**From:** Will Conway  
**Sent:** Tuesday, January 02, 2018 4:00 PM  
**To:** 'Jean Fraser'  
**Cc:** 'Alexander M. Green'  
**Subject:** RE: East Tower and Visitors Parking Garage Site Plan

**Attachments:** Written Submission A -1 East Tower Data Sheet.pdf; Written Submission A -2 Visitor Garage Data Sheet.pdf; Written Submission I -1 Construction Management Plan Update January 2.pdf; Written Submission S - 9A Maintenance of Traffic January 2.pdf; Written Submission S-10 Project Description.pdf; Plan 14C East Tower East Elevation January 2.PDF; Plan 14D East Tower North Elevation January 2.PDF; Plan 14E East Tower West Elevation January 2.PDF; Plan 14F East Tower South Elevation January 2.PDF; Plan 14K Visitor Garage East Elevation January 2.PDF; Plan 14L Visitor Garage North Elevation January 2.PDF; Plan 14M Visitor Garage West Elevation January 2.PDF; Plan 14N Visitor Garage South Elevation January 2.PDF

**From:** Jean Fraser [<mailto:jf@portlandmaine.gov>]  
**Sent:** Wednesday, December 27, 2017 10:46 AM  
**To:** Will Conway <[wconway@sebagotechnics.com](mailto:wconway@sebagotechnics.com)>  
**Subject:** MMC East Tower and Visitors Parking Garage Site Plan

Ambulance Routes

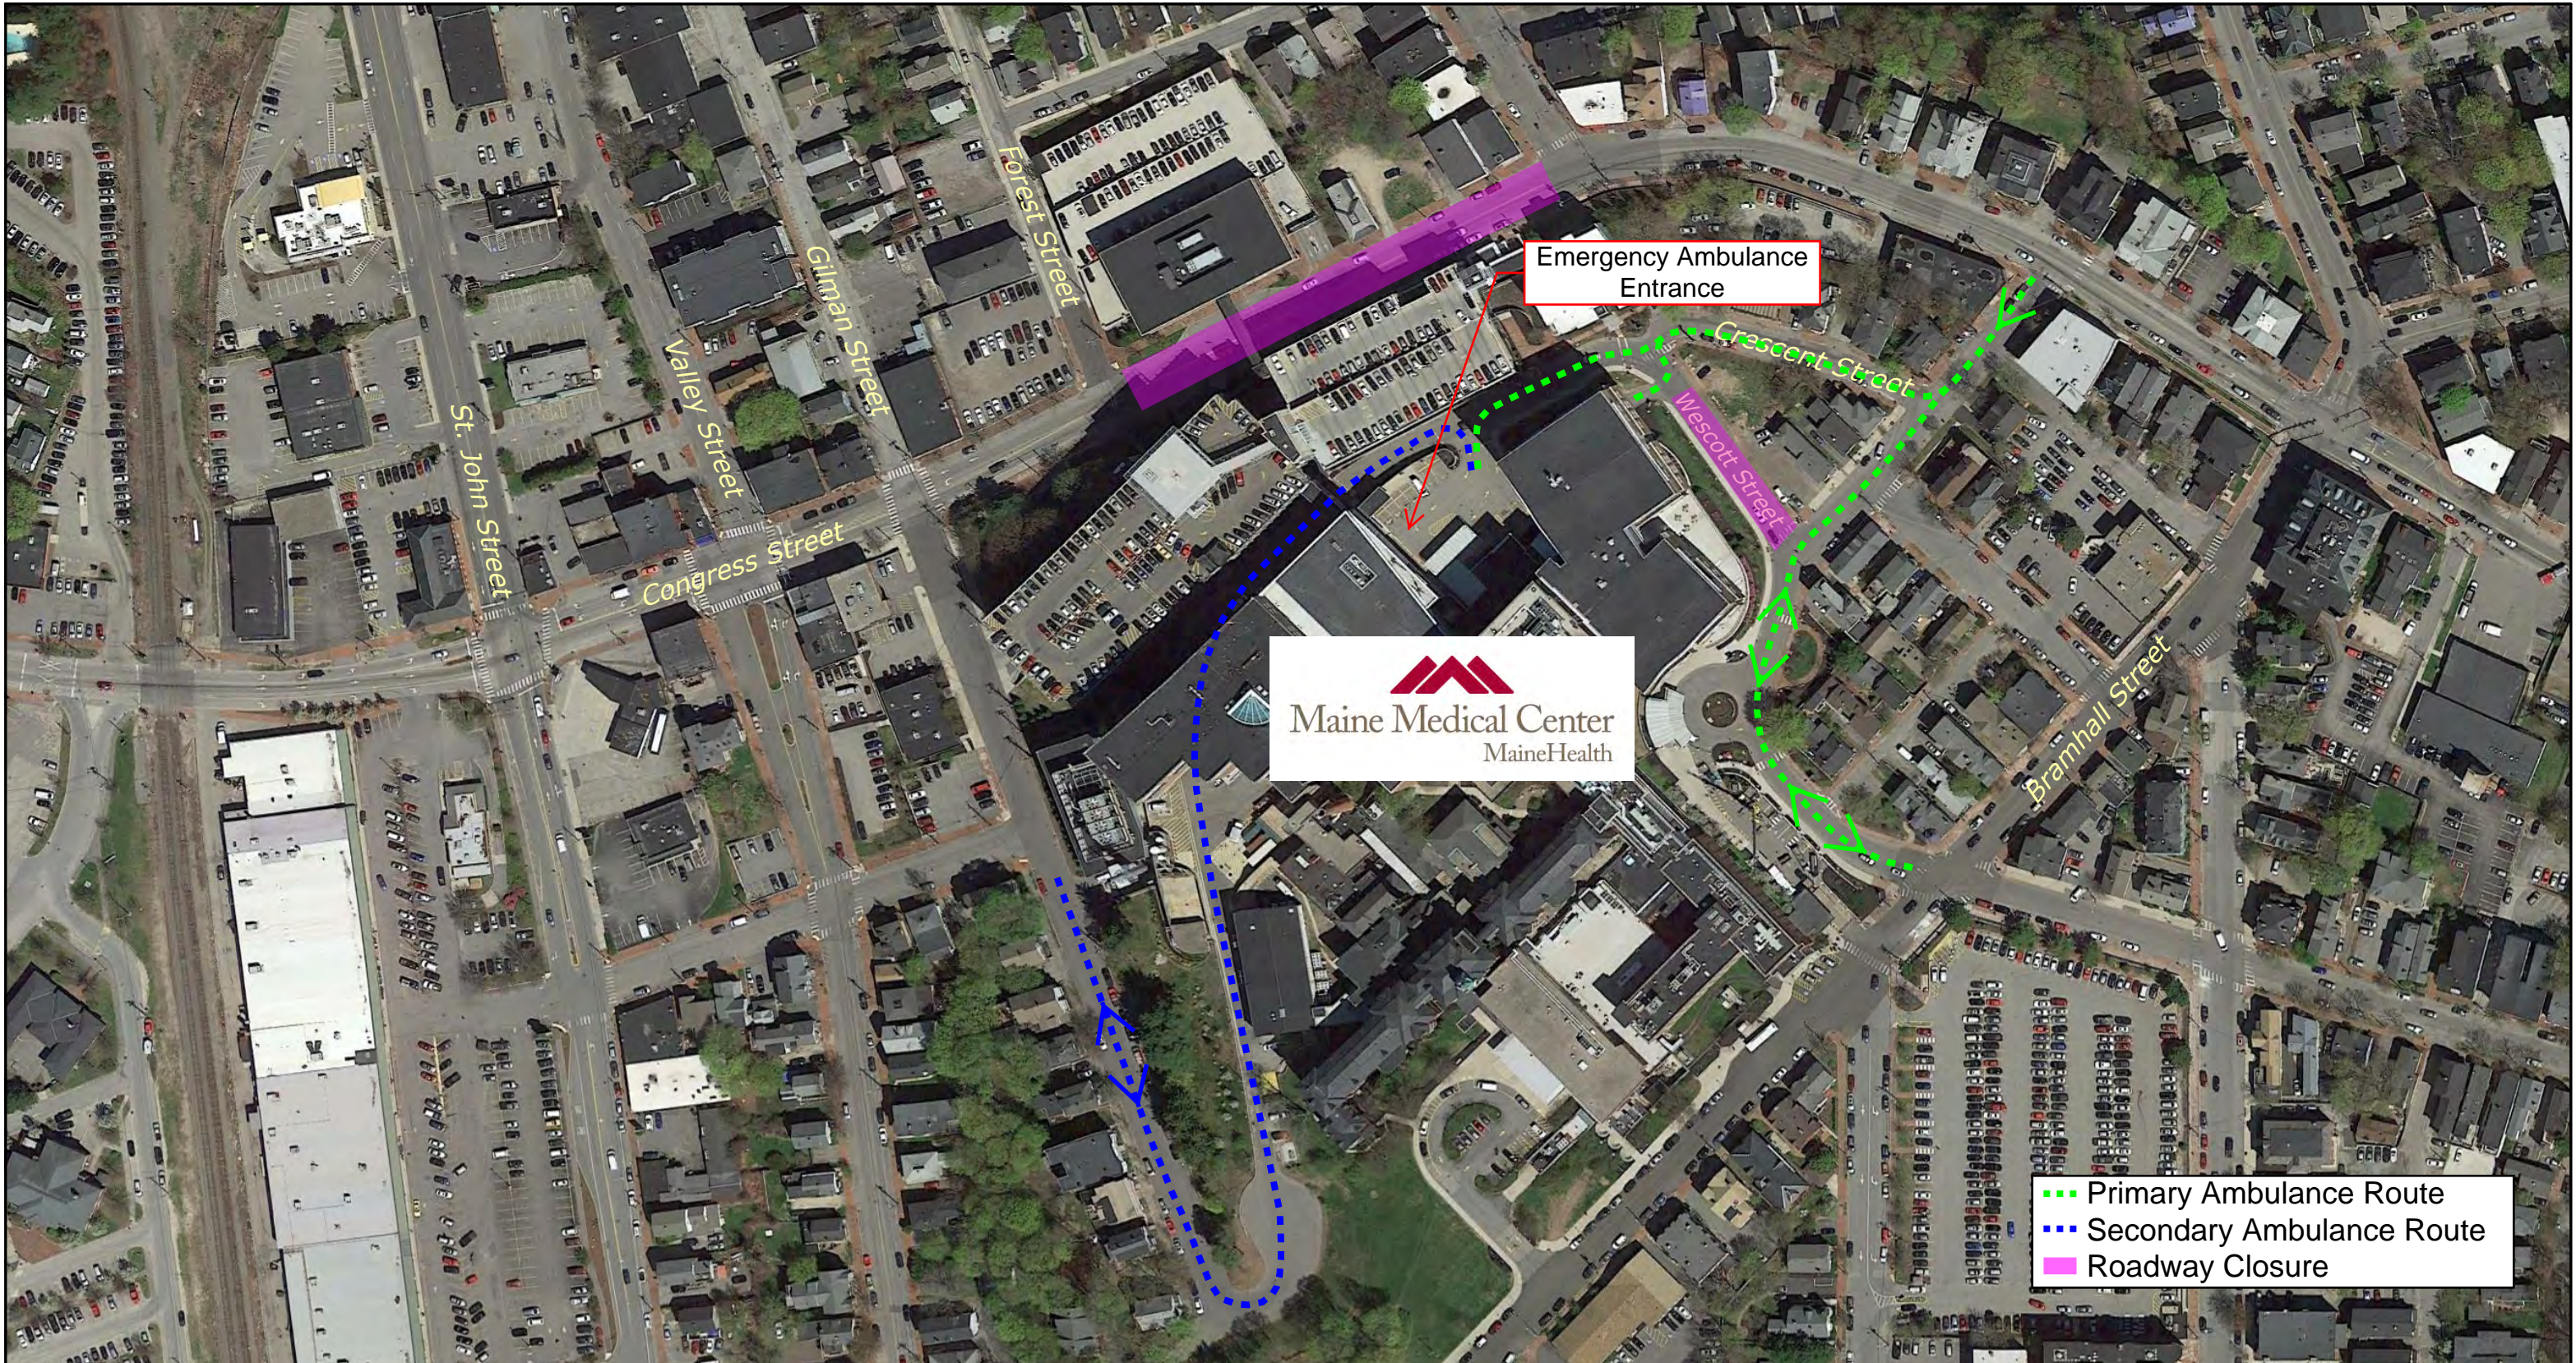
- Ambulance route during construction Ambulances travel on Crescent Street in each direction from May 14-July 12, 2019. See Written Submission S- 9A Maintenance of Traffic Update dated January 2.

Visitor Garage Expansion

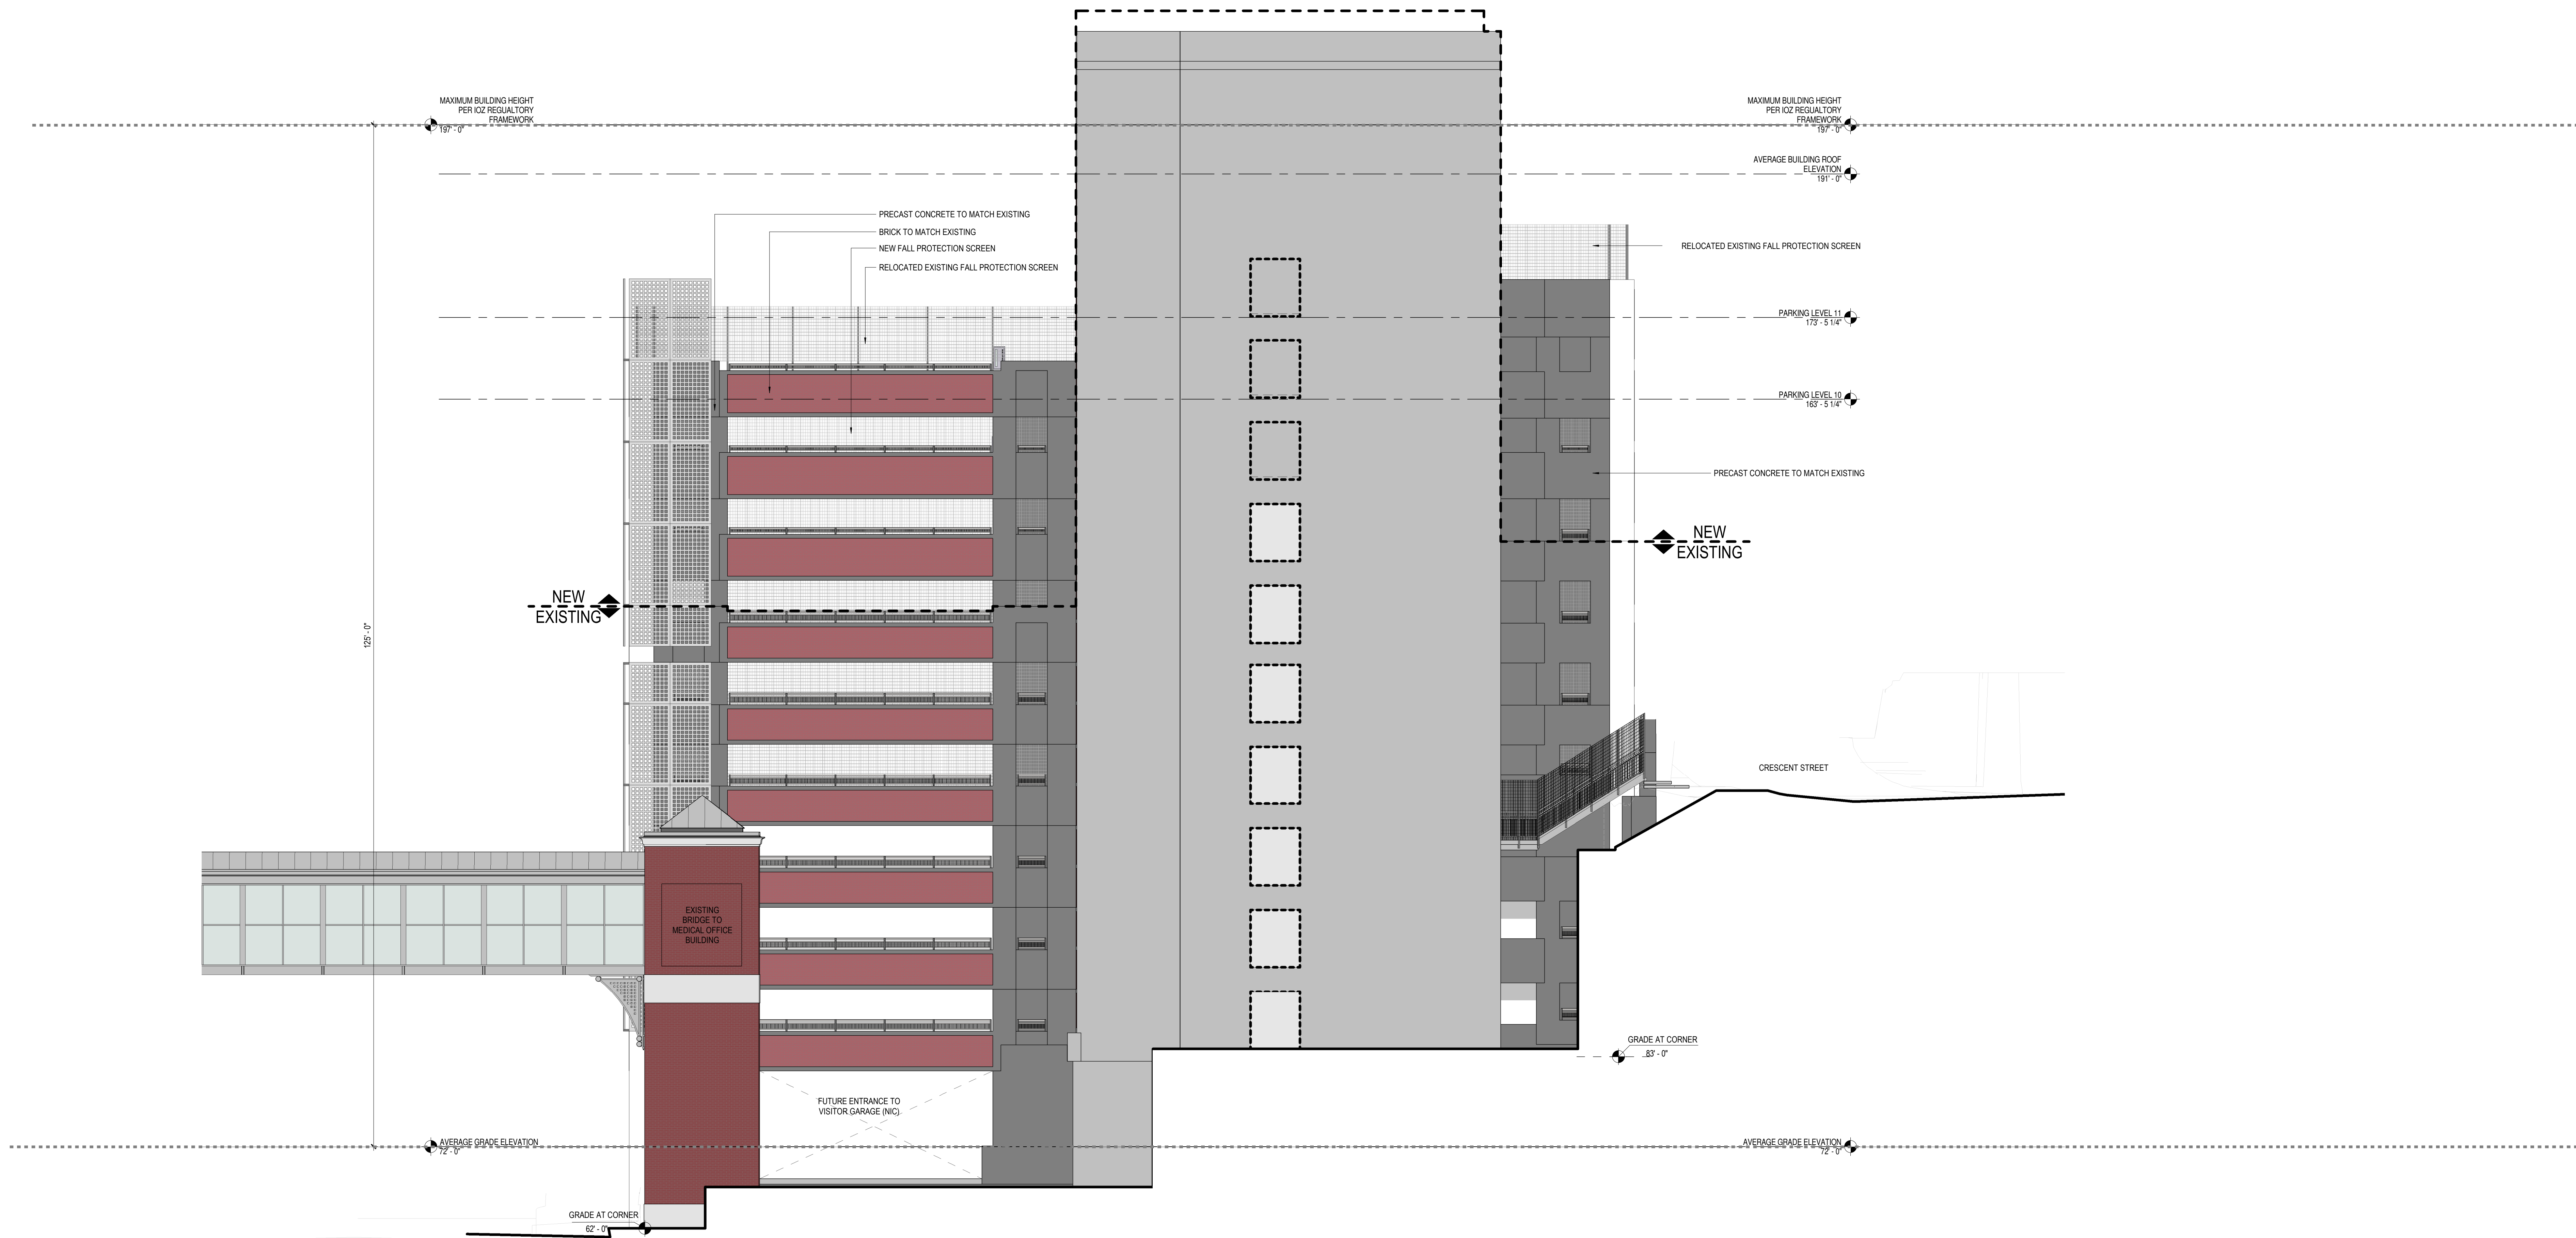
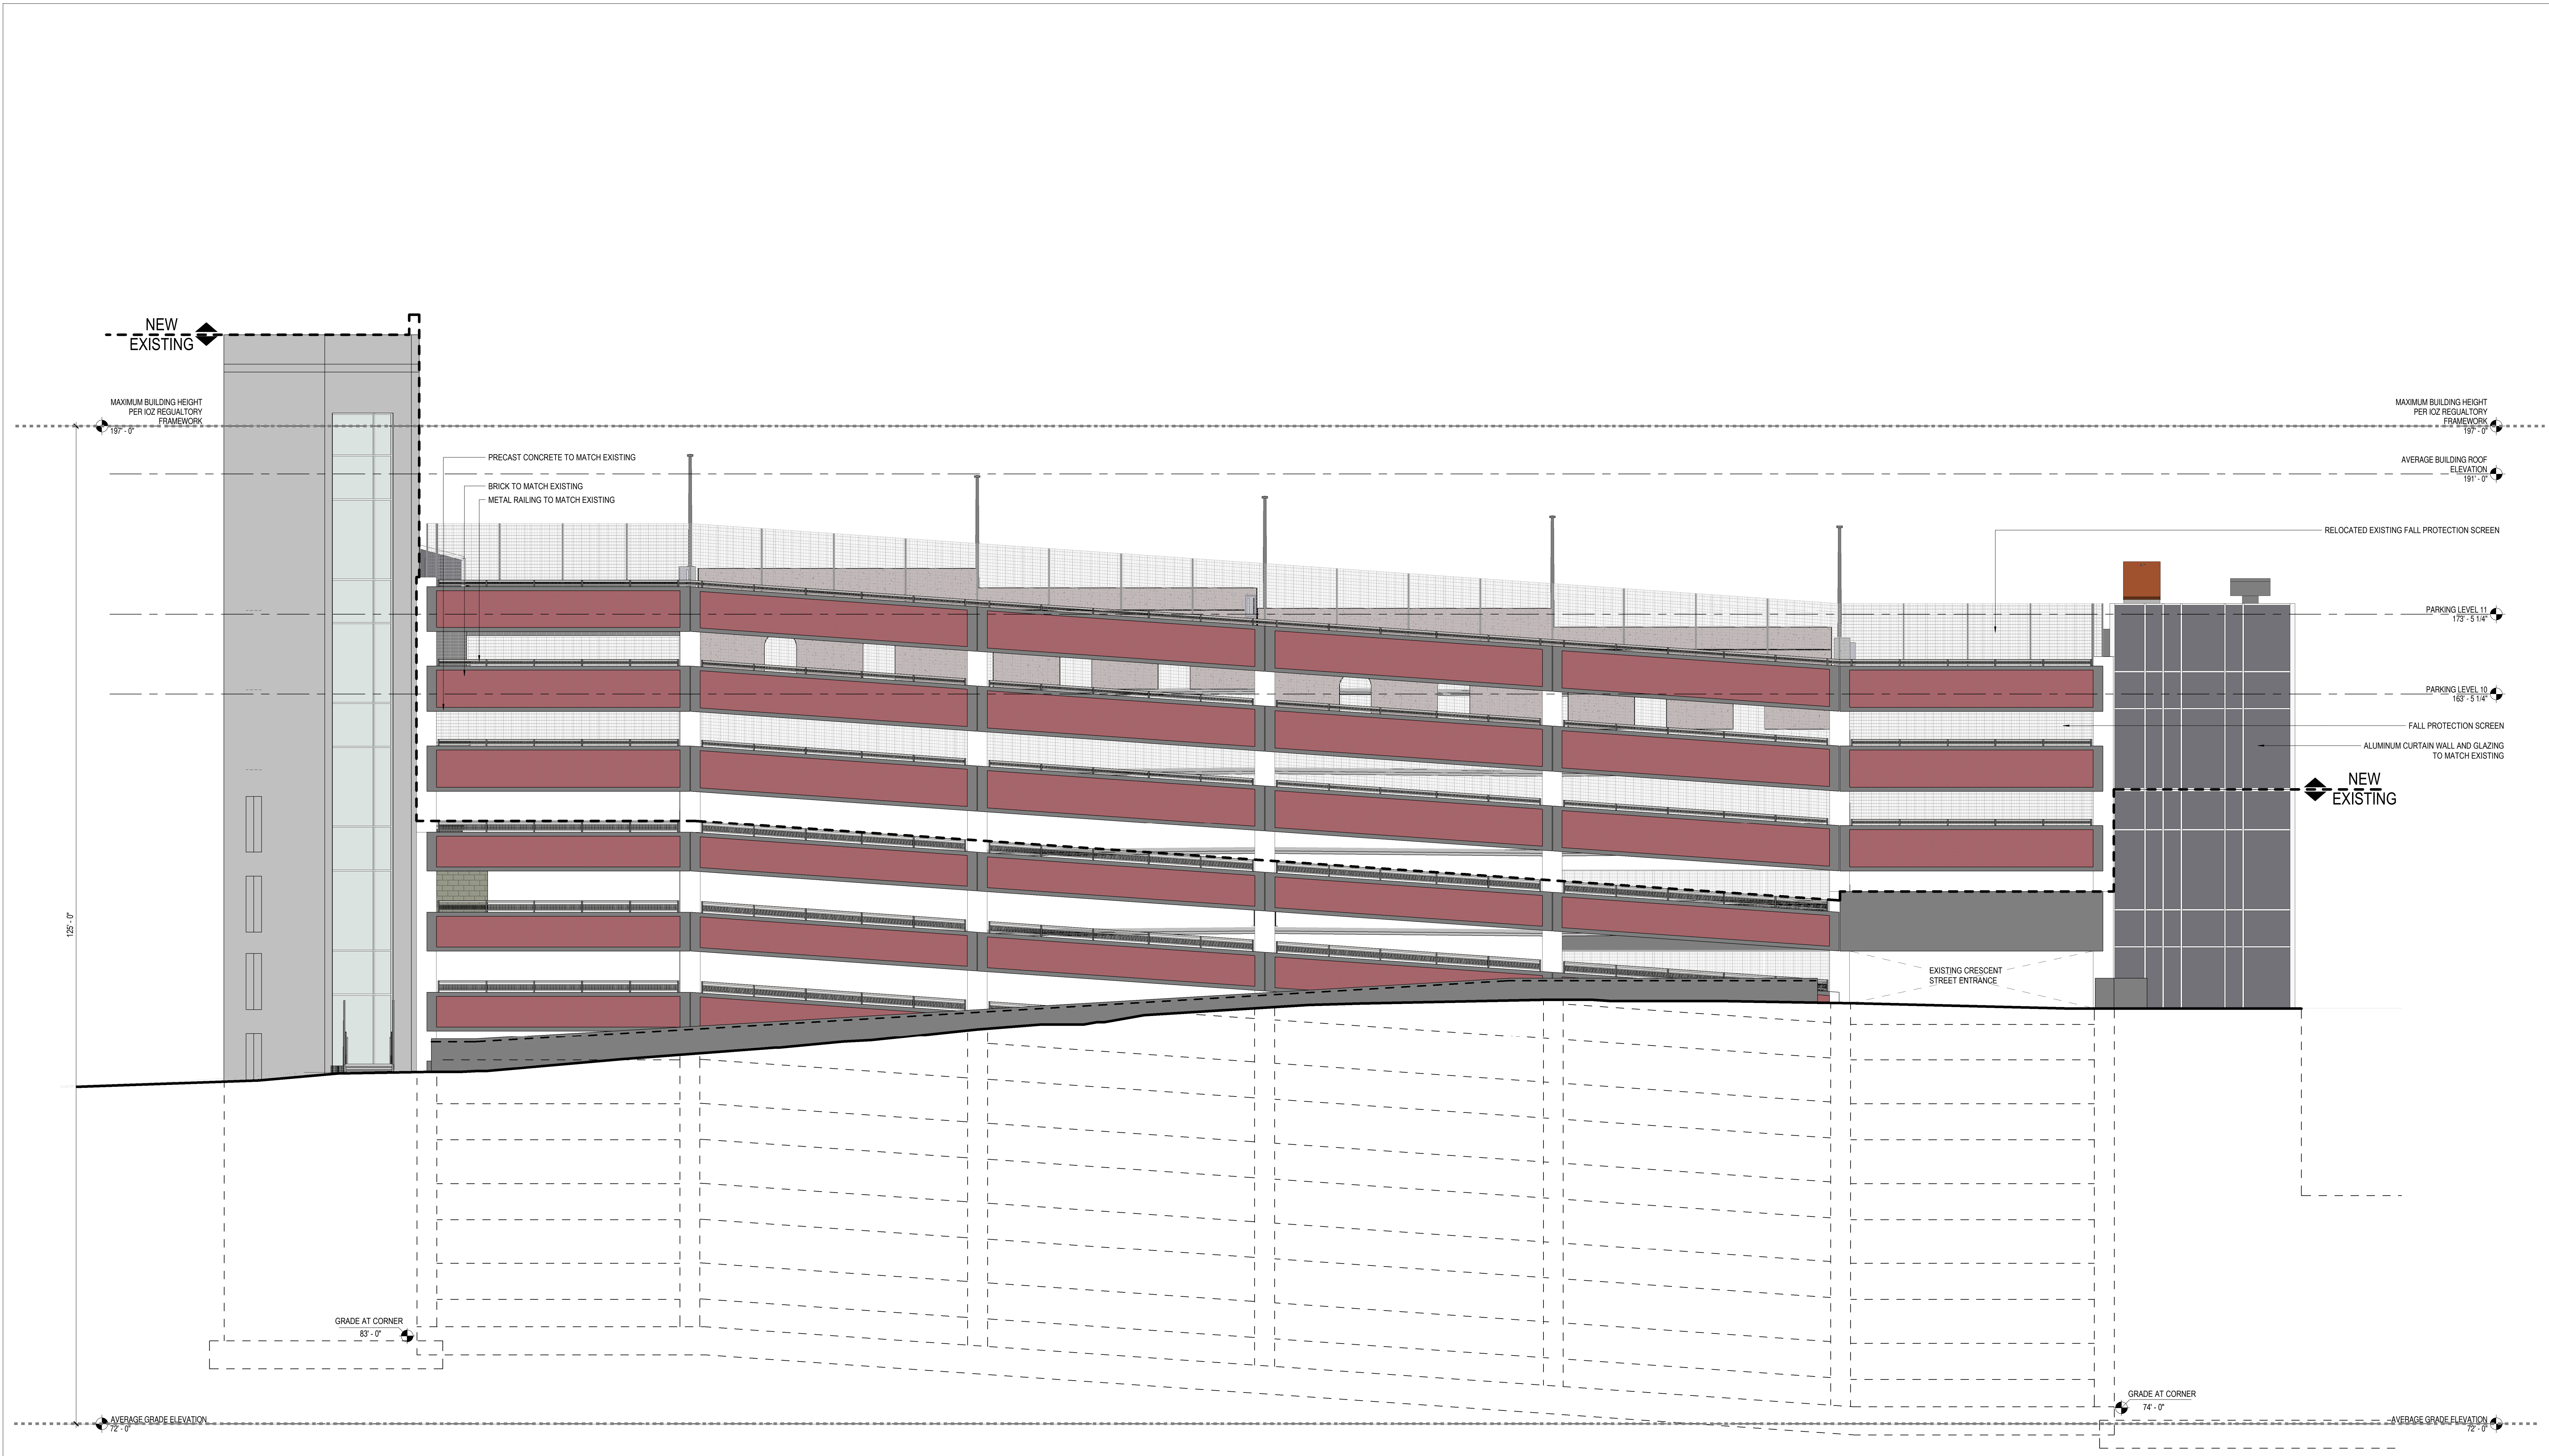
- Separate data sheets for each building See Written Submission A-1 and A-2.
- Elevations that show the existing compared to the proposed (either annotate the proposed elevations, or send in existing elevations or matching existing photos); See revised Plans 14C – 14N dated January 2.

- Elevations need to show the average grade (measured in accordance with our ordinance). See revised Plans 14C- 14N dated January 2.
